From: Richard Castro-Parker
Sent: 23 September 2019 12:02
To: Samantha Lee
Subject: RE: BE/139/18/PL - Innovation Centre Beeding Close

From: Laura Gibbons
Sent: 30 August 2019 11:57
To: Richard Castro-Parker <Richard.Castro-Parker@arun.gov.uk>
Subject: RE: BE/139/18/PL - Innovation Centre Beeding Close

I still am struggling to distinguish between lines. Please can different line types be used, rather than all very similar colours. Please can gullies, manholes, and linear drainage channels be clearly labelled.

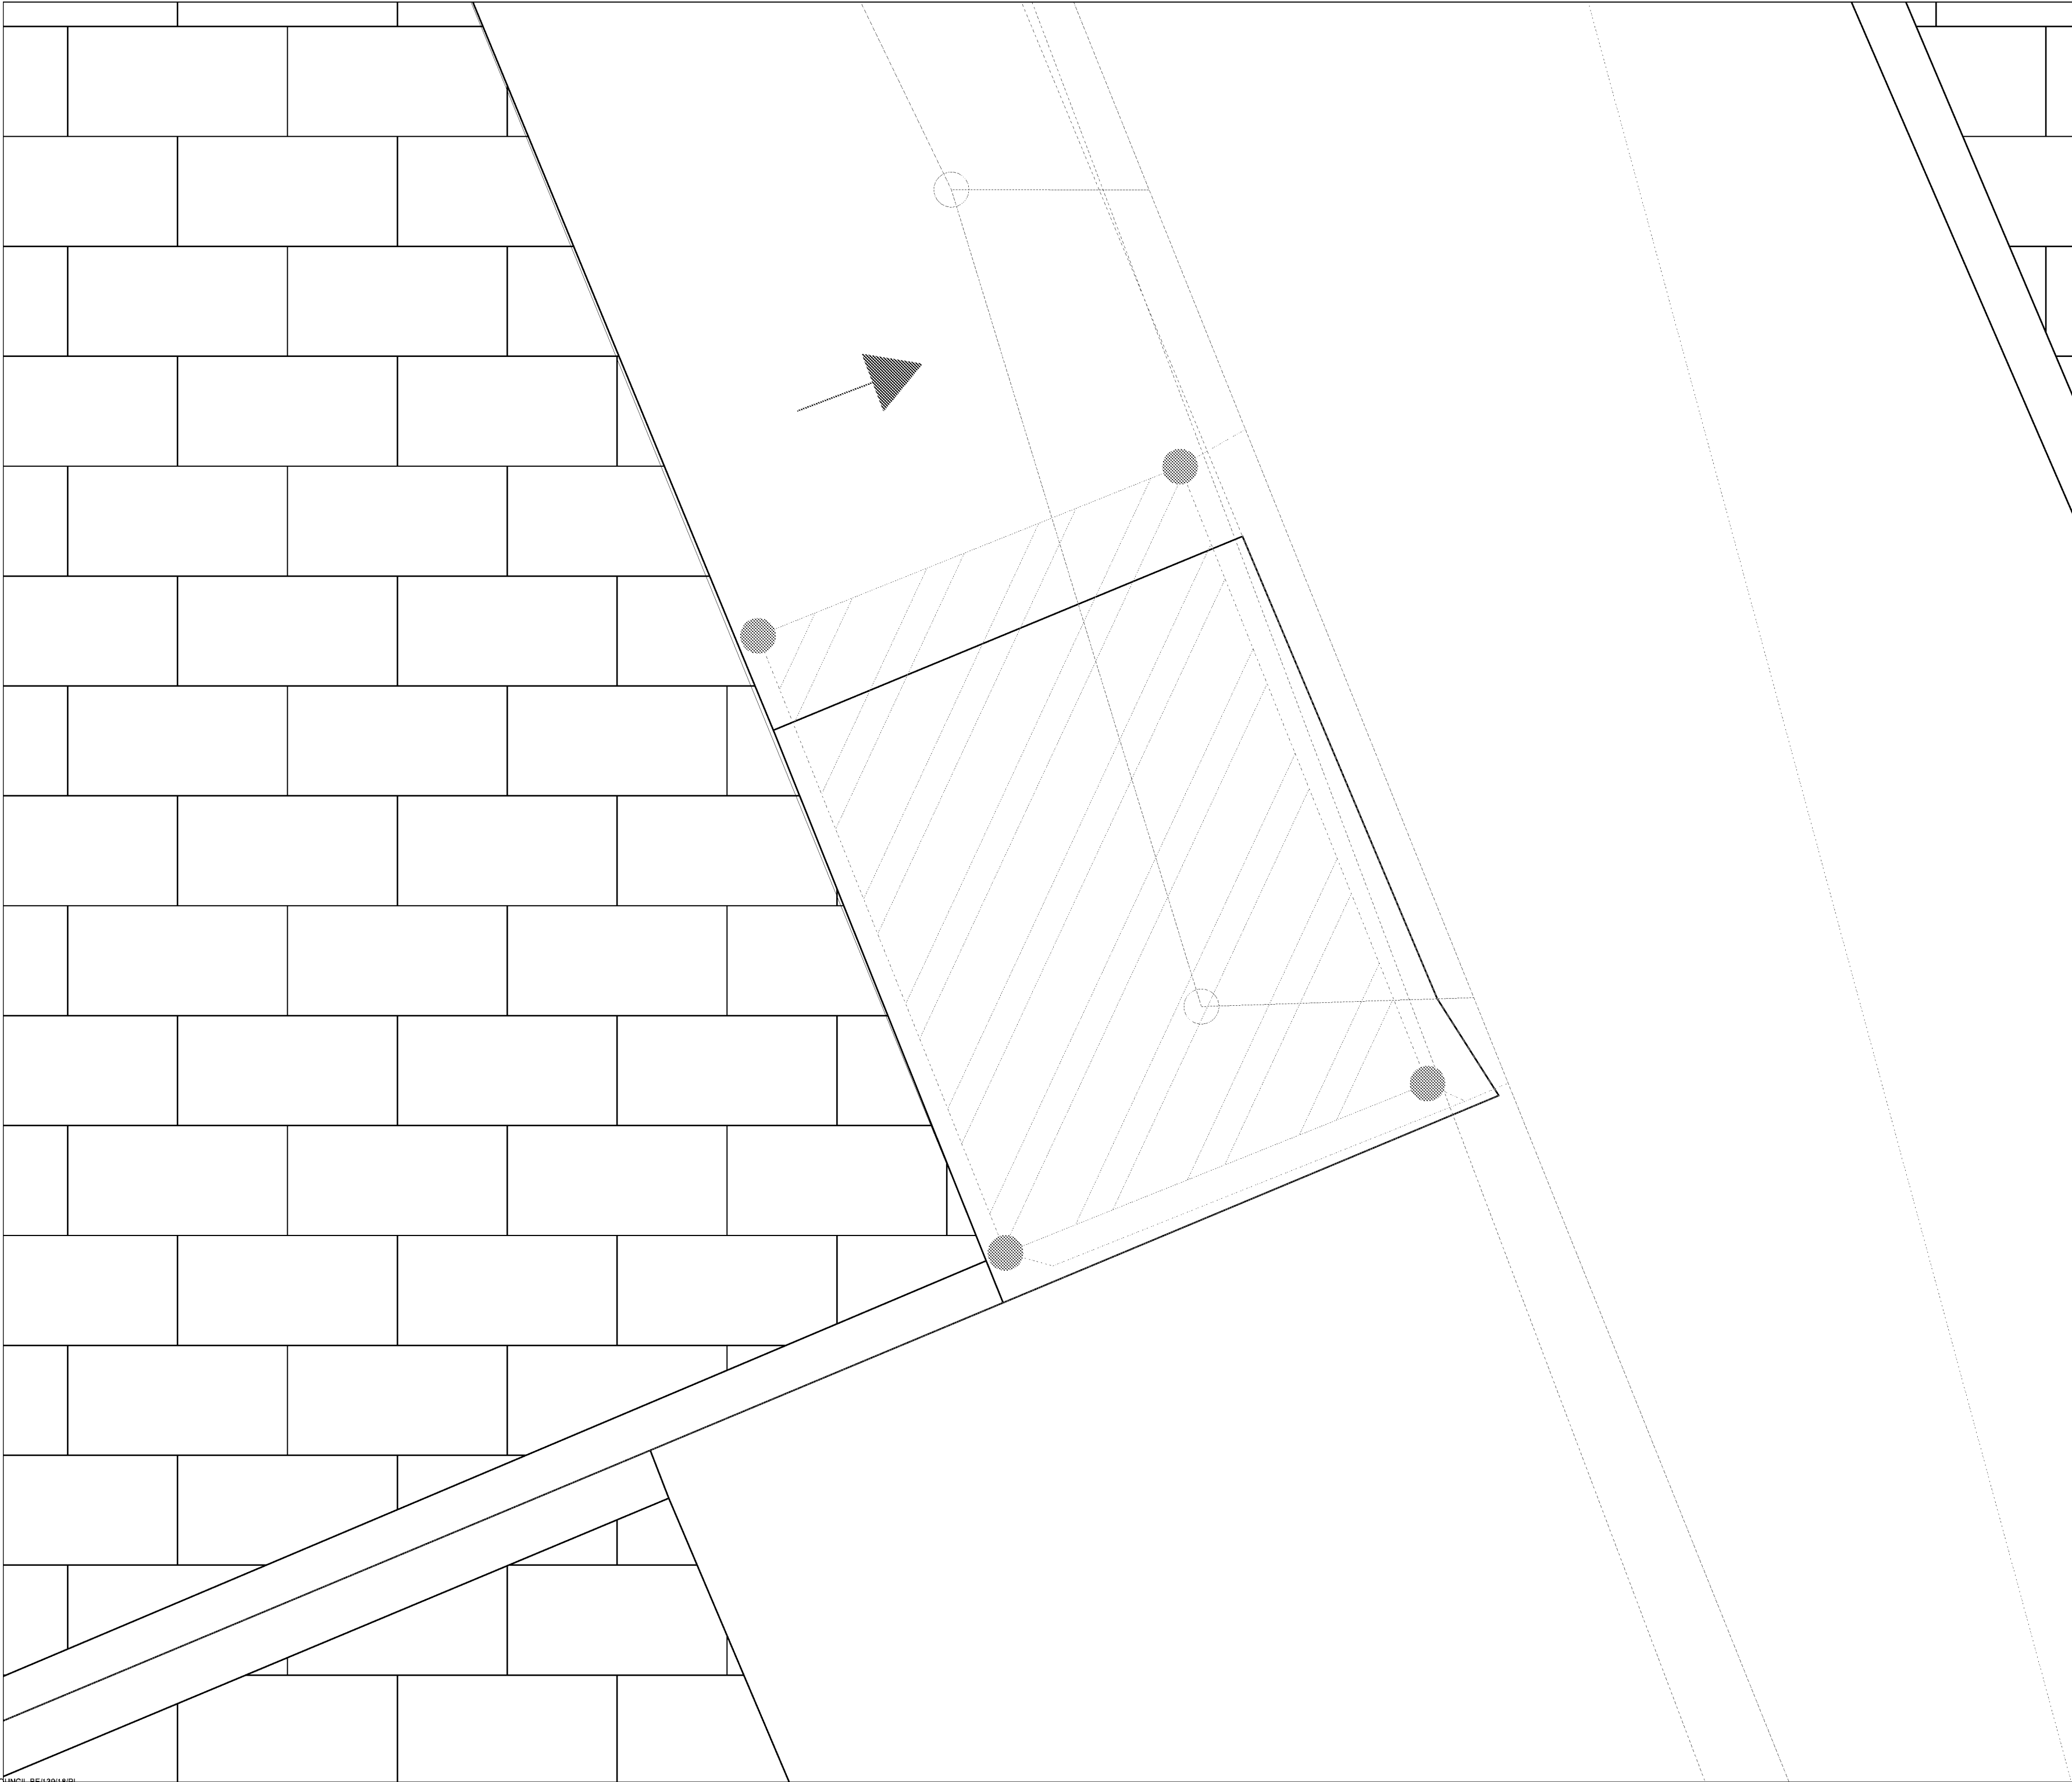
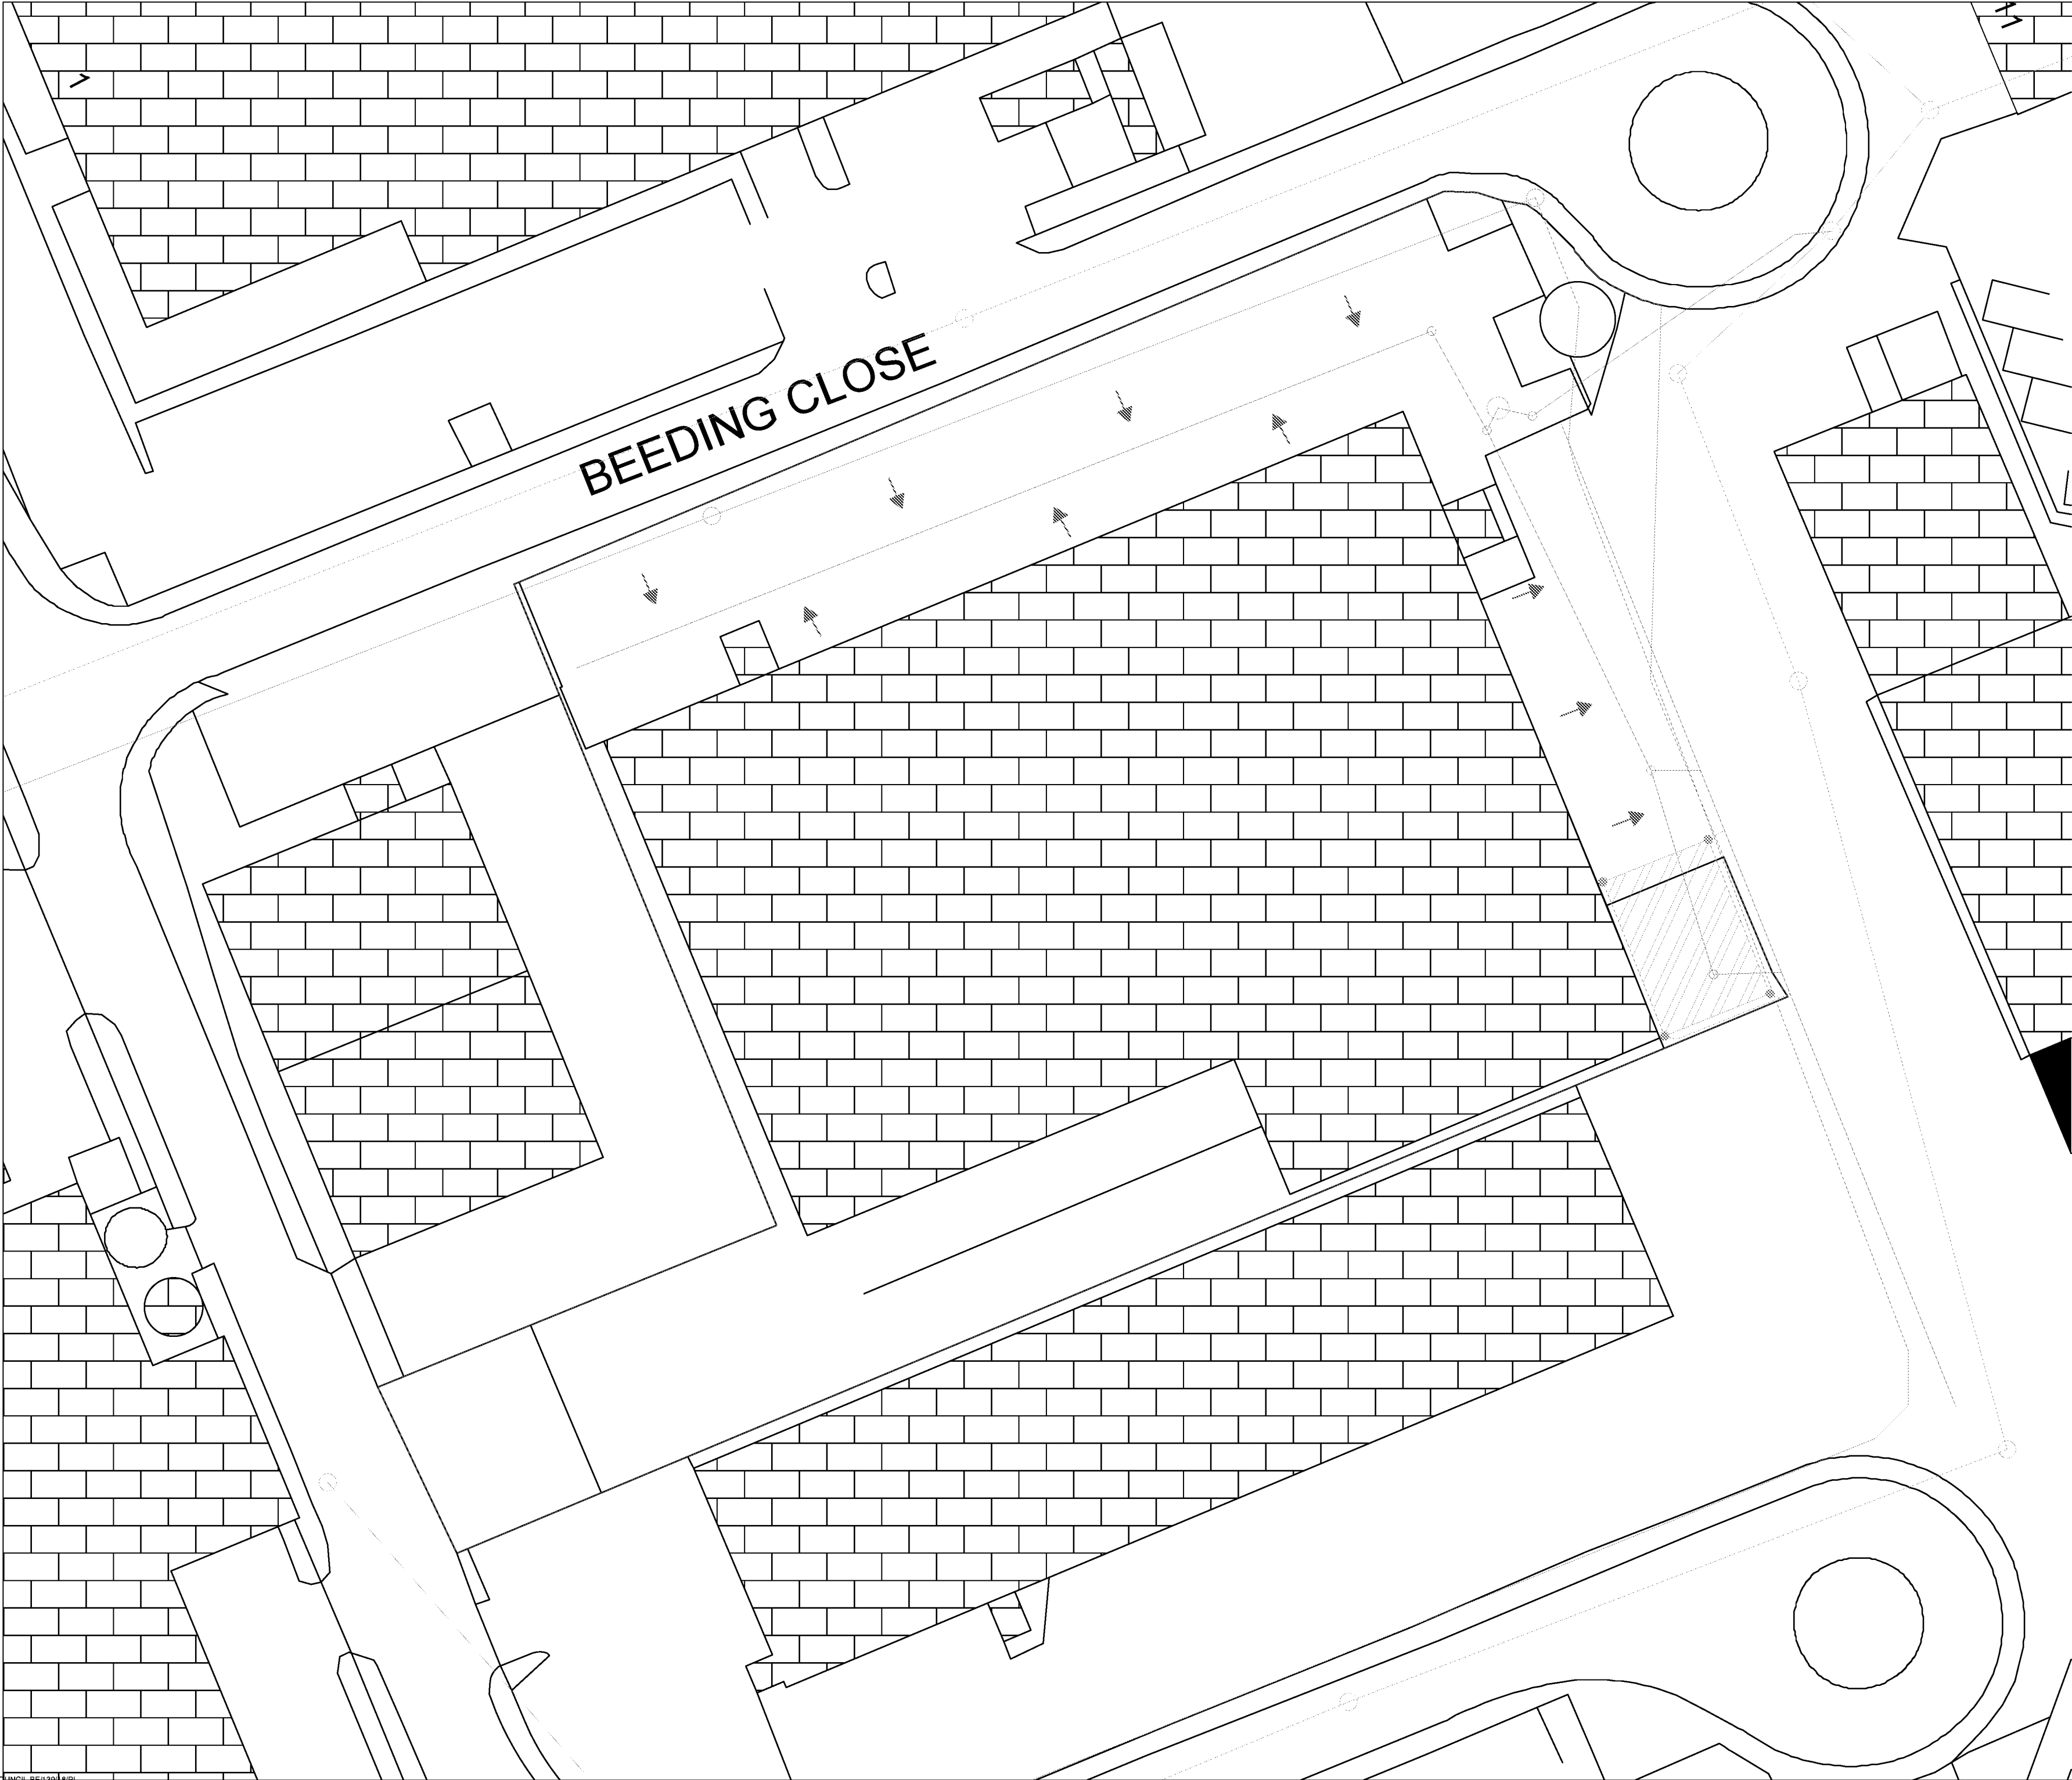
Regarding the levels, I also requested some spot levels of the surrounding land, can these be provided. This is fundamental to ensure that the surface water from the development does not go off site.

Please can the applicant submit clearer plans of the proposed surface water drainage arrangement. I.e. different line types used, rather than all very similar colours. Please can gullies, manholes, and linear drainage channels be clearly labelled.

I also require levels to be submitted showing invert and cover levels of the existing drainage network and spot levels of the surrounding land. This is fundamental to ensure that the surface water from the development does not go off site.

The colour of the lines have been changed and it is very different from each other in my screen. Please therefore let me know if Laura is still unable to distinguish them. I've also got confirmation from the client that they already have someone booked in to have the drainage cleaned.

With regard to spot levels, could Laura ascertain whether the Environment Agency LIDAR information would be sufficient information to determine the rough elevation of the surrounding land? Unfortunately, our flood consultant is not qualified to undertake a topographical survey of the surrounding land. We will therefore have to appoint a surveyor separately just to do the full survey for the displacement of 150sq.m of roof water.

Please find attached a PDF of the drainage layout plan for the site. Given the size of the site, all lines on the plans are small. However, if Laura zooms in she will be able to distinguish between the pipes types. This should hopefully address her first concern.

With regards to levels, having reviewed the sewer asset location search requested from Southern Water, both invert and cover levels for all Southern Water manholes are detailed within their response. A copy of the sewer asset location search was included within the appendix of the Surface Water Drainage Strategy – this have been attached to this email for her reference.
